From: [REDACTED]
Sent: 26 January 2026 08:06
To: Planning
Subject: App 3/2025/0984 Coxes Farm Stoneygate Lane Ribchester PR3 2ZS - Ecology Unit Response

App 3/2025/0984 Erection of a timber-framed agricultural building with stable and additional hardstanding, Coxes Farm Stoneygate Lane Ribchester PR3 2ZS

Block Plan-O.S Map 4.2

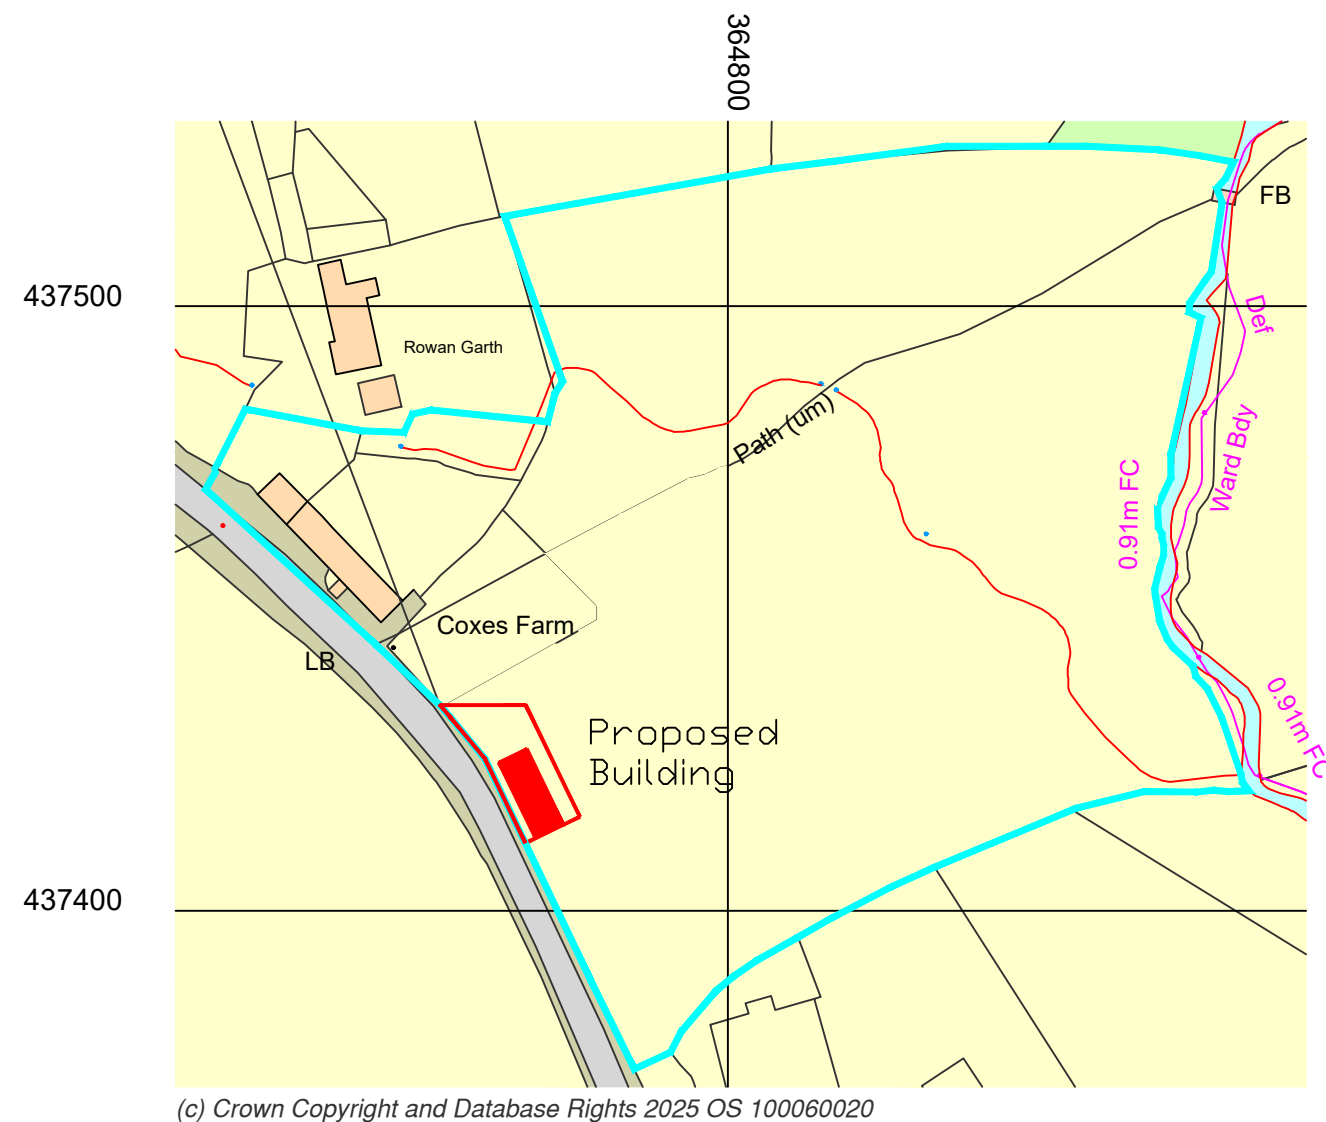
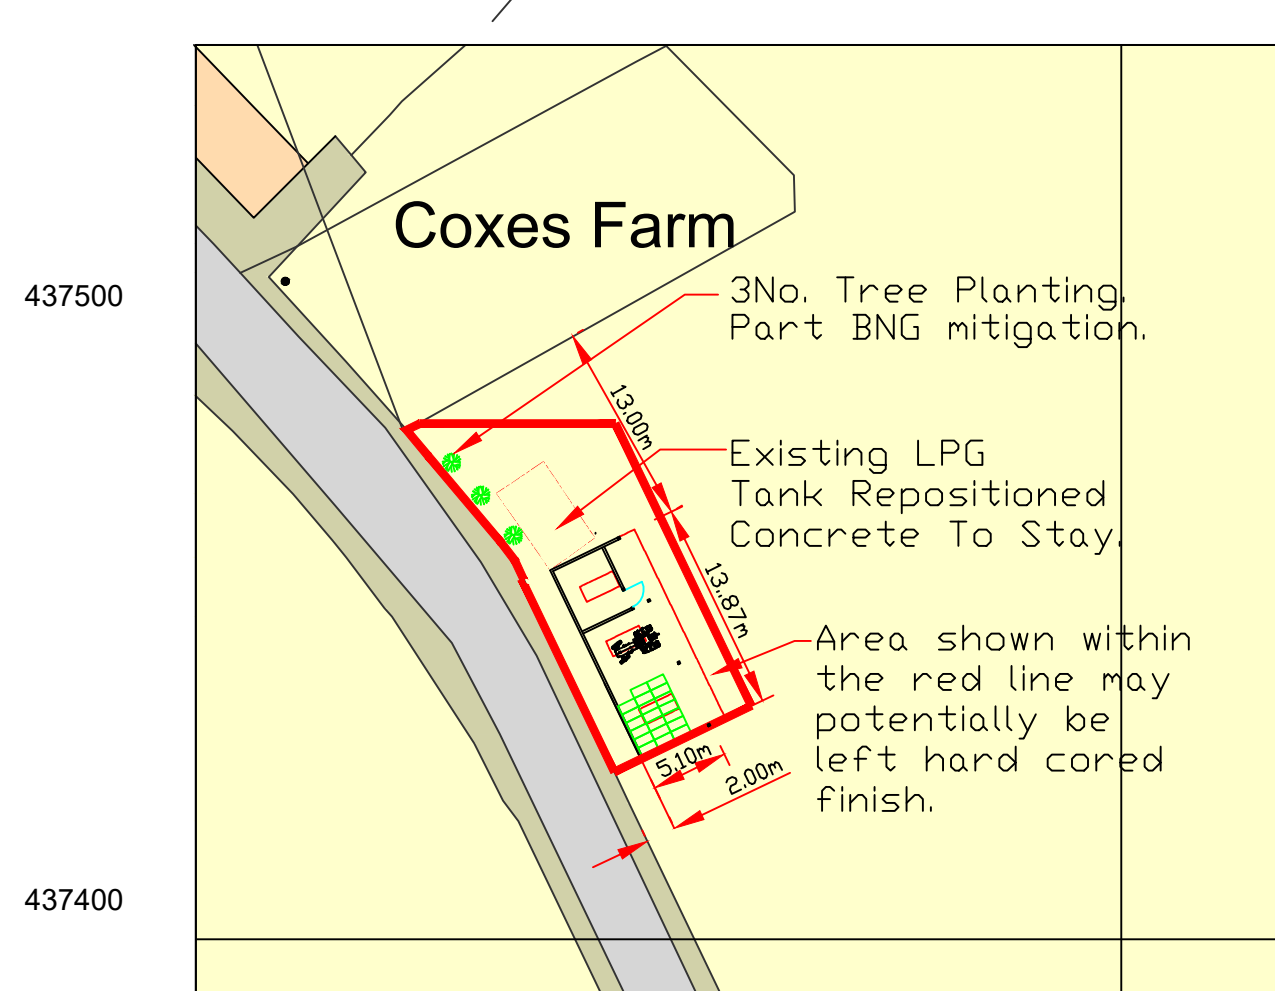
I'm not entirely clear from the plans provided as to whether any of the hedgerow along Stoneygate Lane will need to be removed for additional access to the new buildings. If part of the hedgerow does need to be removed then compensation will need to be offered for this habitat loss, and the biodiversity net gain metric will need to be amended. But if existing access points are to be used, and no hedgerow lengths removed, then I would raise no objections to the proposals on Ecology grounds. Confirmation on this point would be useful.
